Good afternoon Ellena,

Council generally concurs the comments provided by Murray River Council, dated 22 July 2024, and is cautiously optimistic as to the social and economic benefits that a project such as this can bring to our community.

Council generally accepts that the EIS has discussed a range of matters in conceptual terms as previously communicated to the Dept and the Proponent. It will be important for the proponent to engage with Council during the preparation of management plans and codes of conduct, as described throughout the EIS, in order to minimise any negative potentialities around social, transport and waste, while maximising community enhancement.

Junction Rivers Wind Farm - 100m Blade from Adelaide
 KM Index 623.7: Sturt Highway / Market Street, Balranald
 Strategic Design - Option A

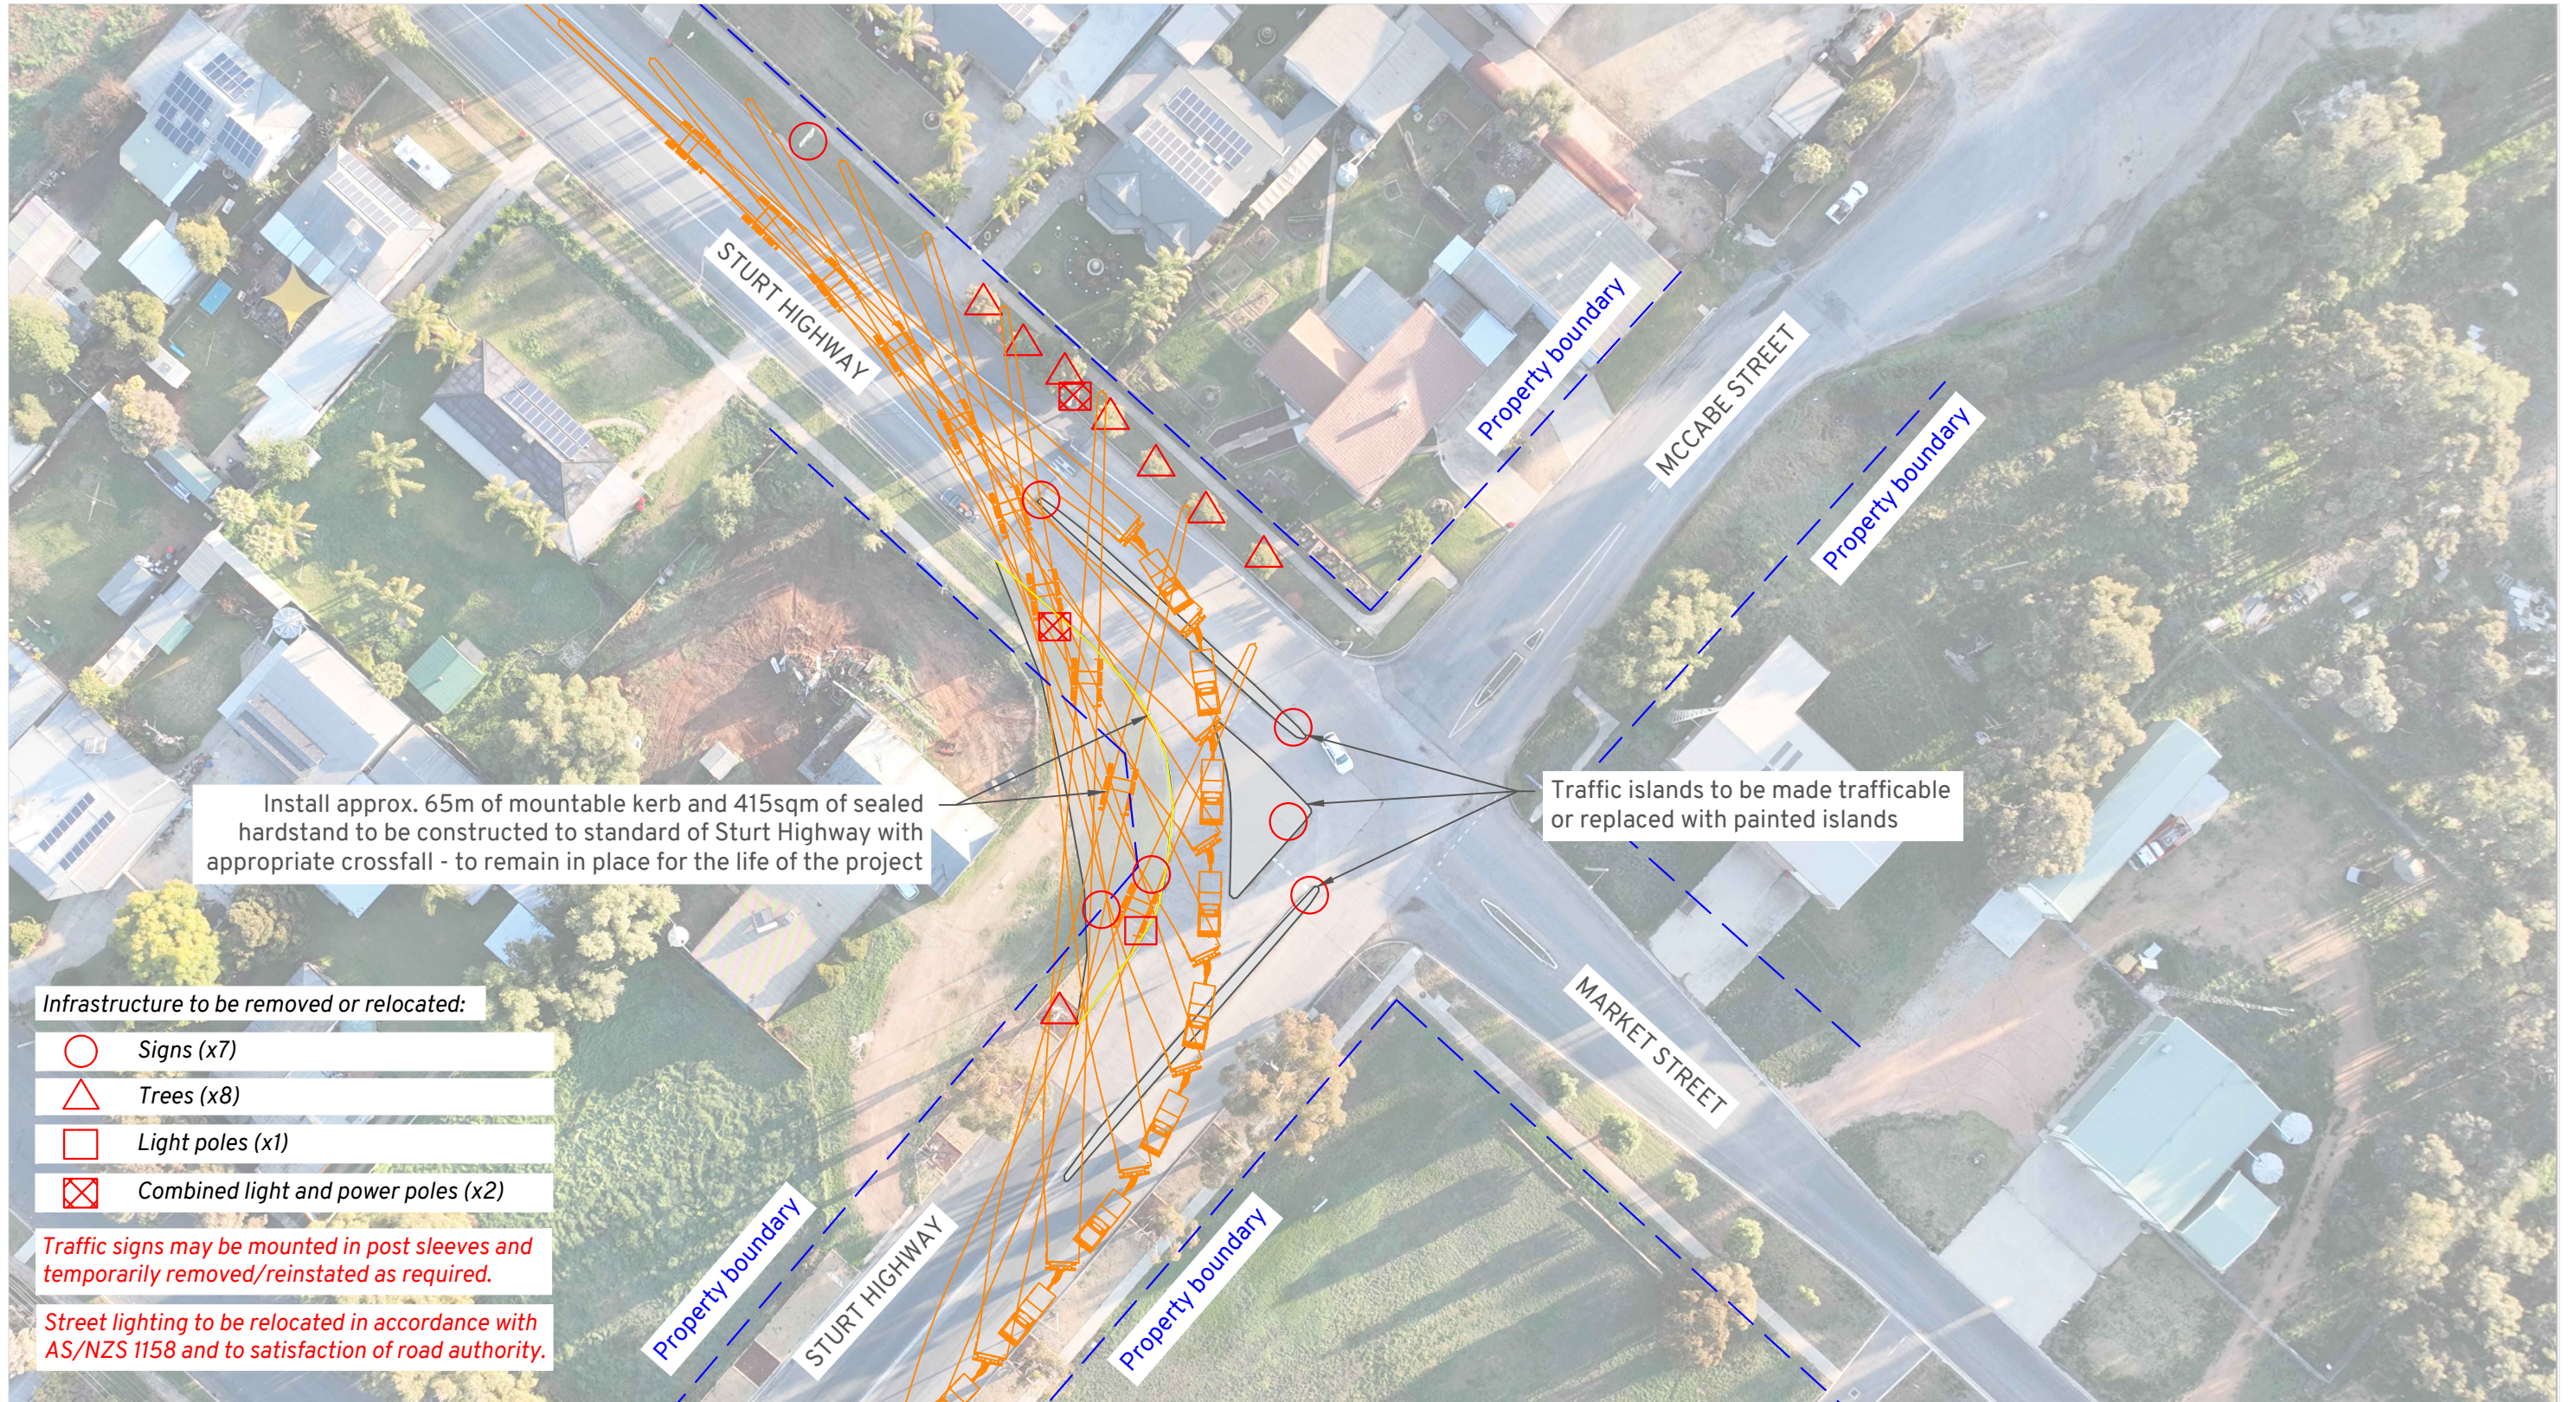
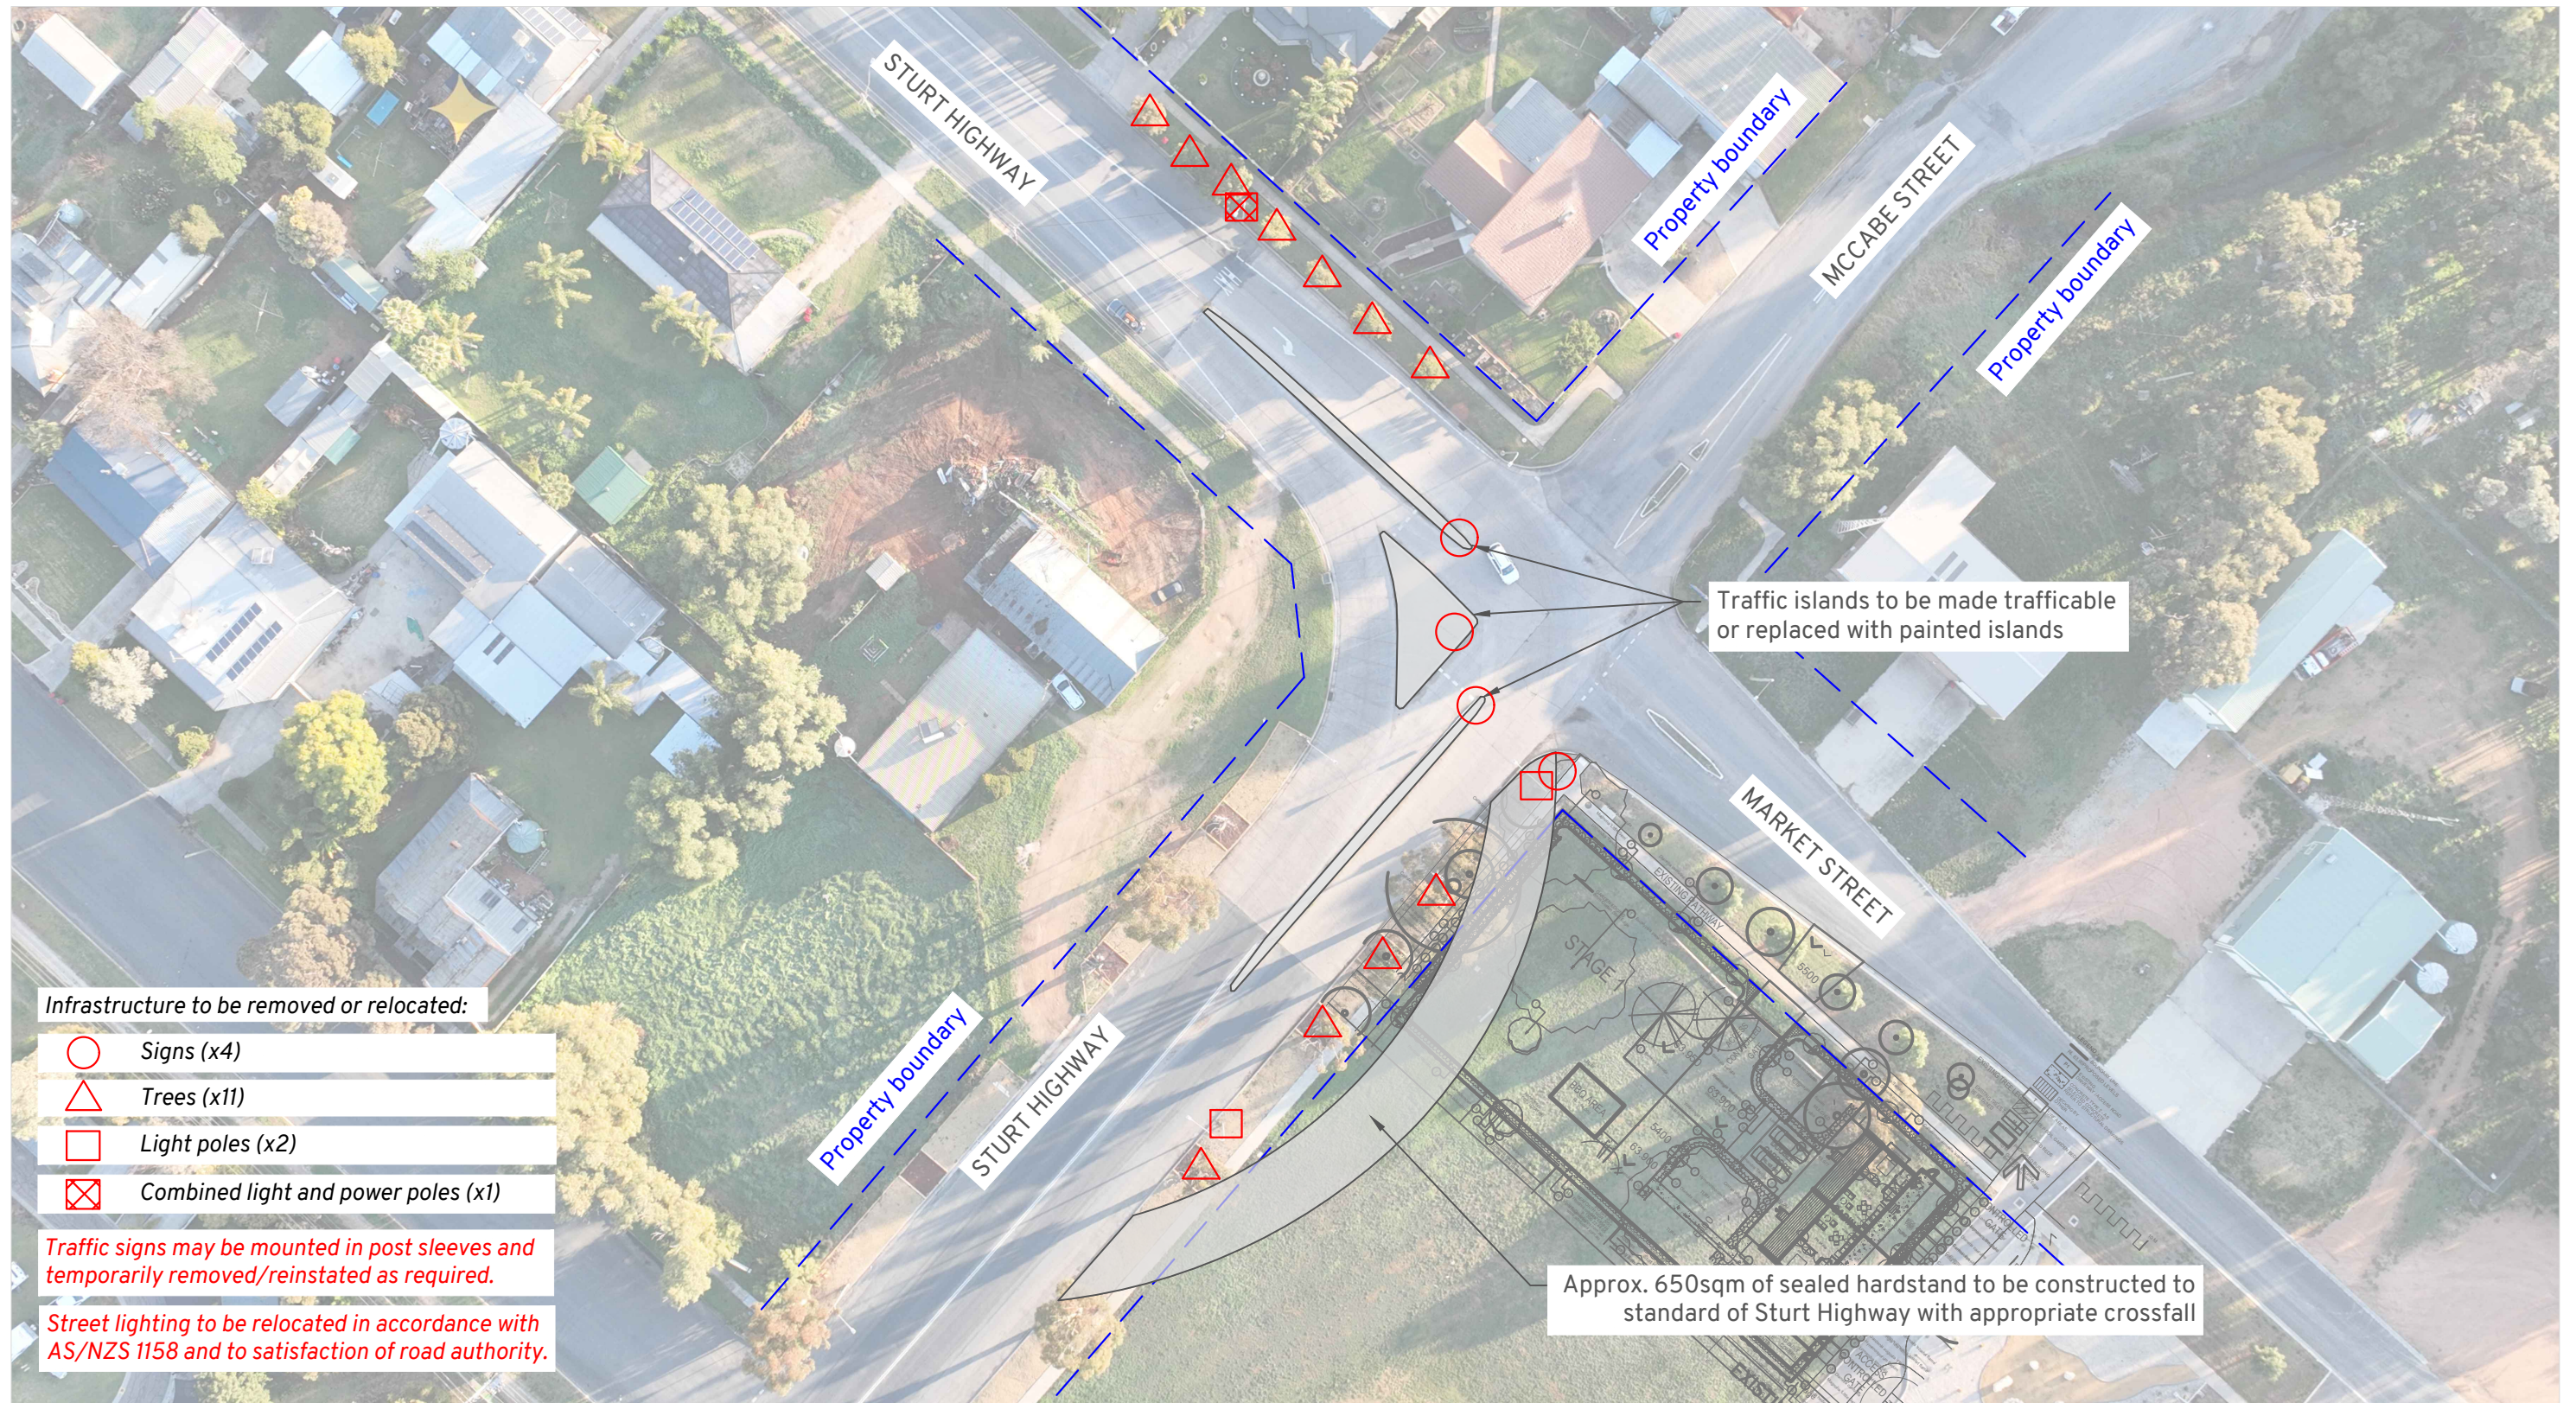
It will be important for the proponent to engage with Council in relation to the Euston roundabout and Market St/Sturt Highway McCabe St intersection treatments around impacts, mitigation and restoration of Council infrastructure at these locations.
